From: Richard Temple
Sent: 17 January 2018 11:24
To: Planning.Responses
Subject: FW: BR/280/17/PL Land adjacent to 8 Mead Court

Application Number	BR/280/17/PL
Address	Land adjacent to 8 Mead Court Mead Lane Bognor Regis PO22 8BL
Description	1 No. dwelling. This application may affect the setting of Listed Buildings & affects the character & appearance of the Upper Bognor Road & Mead Lane Conservation Area.
Case Officer	Mr R Temple
Date	10 th January 2018

Front Elevation

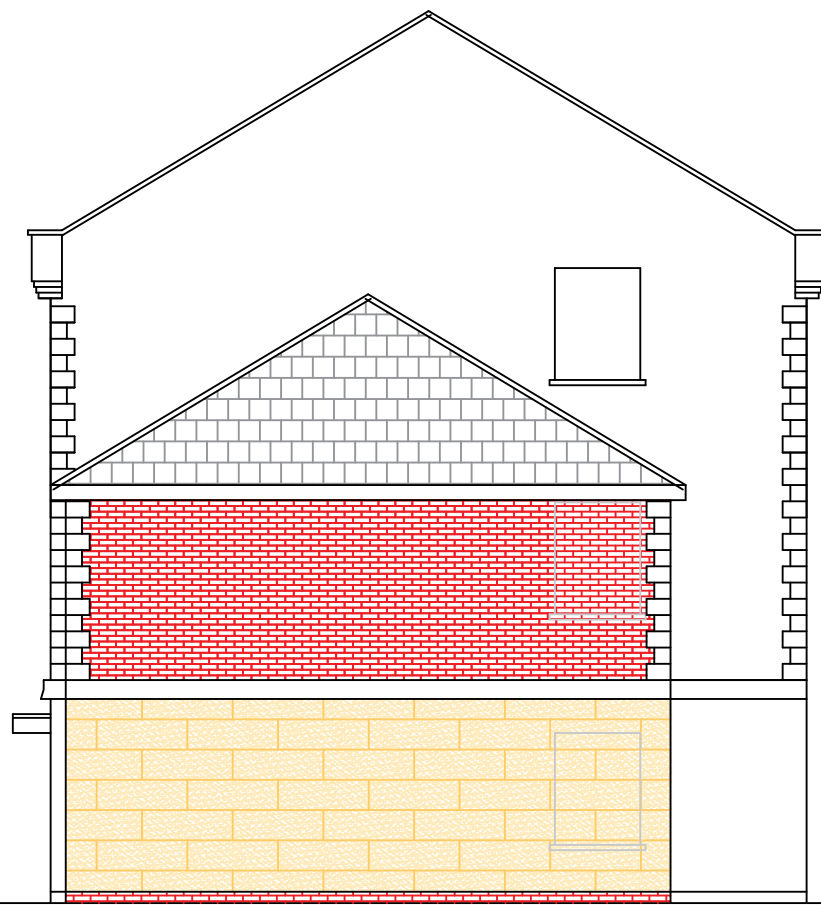
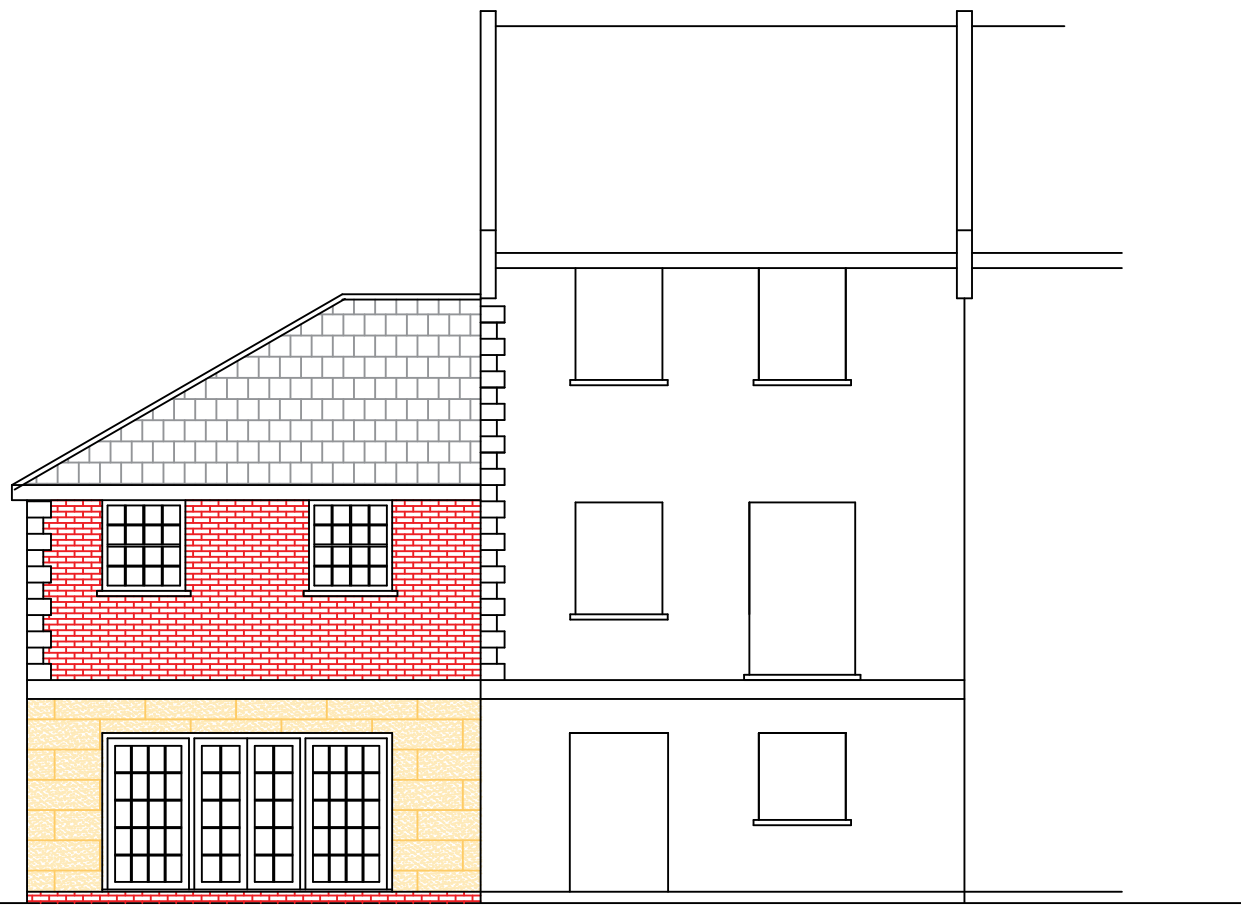
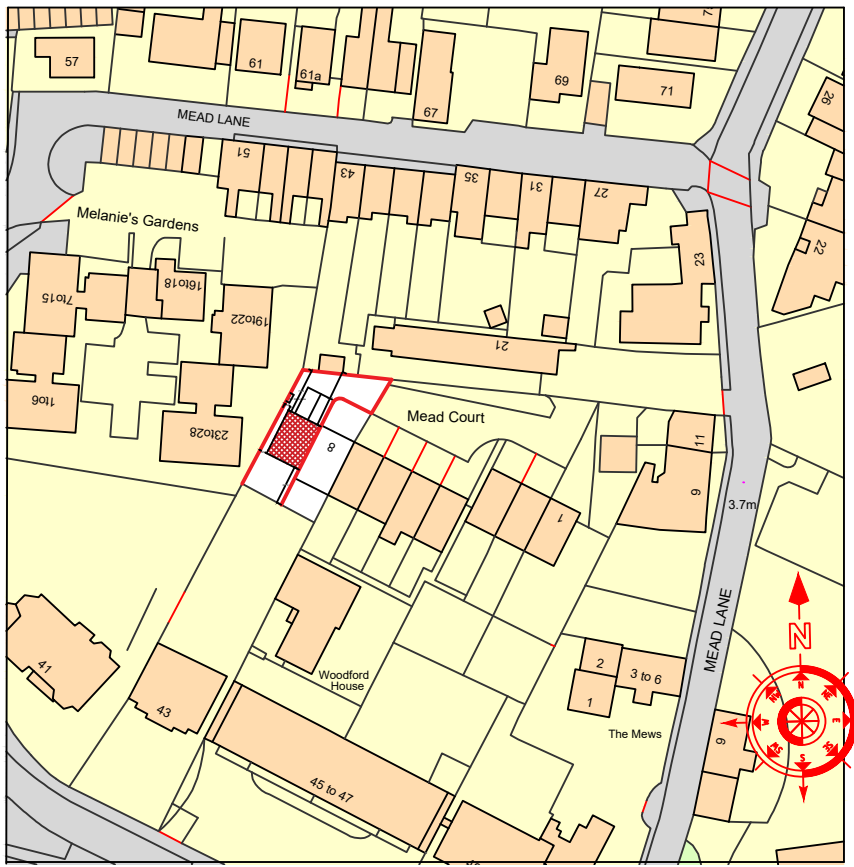
The proposed design is at odds with the existing terrace in terms of roof profile, material, having a hipped roof, and detracts from the overall visual massing of the existing terrace, and does not respond to the existing building, nor its setting. The application also affects the setting of two listed buildings (above), and in addition, would be visually intrusive within the Conservation Area, being visible from the Upper Bognor Road between the two listed properties (above).
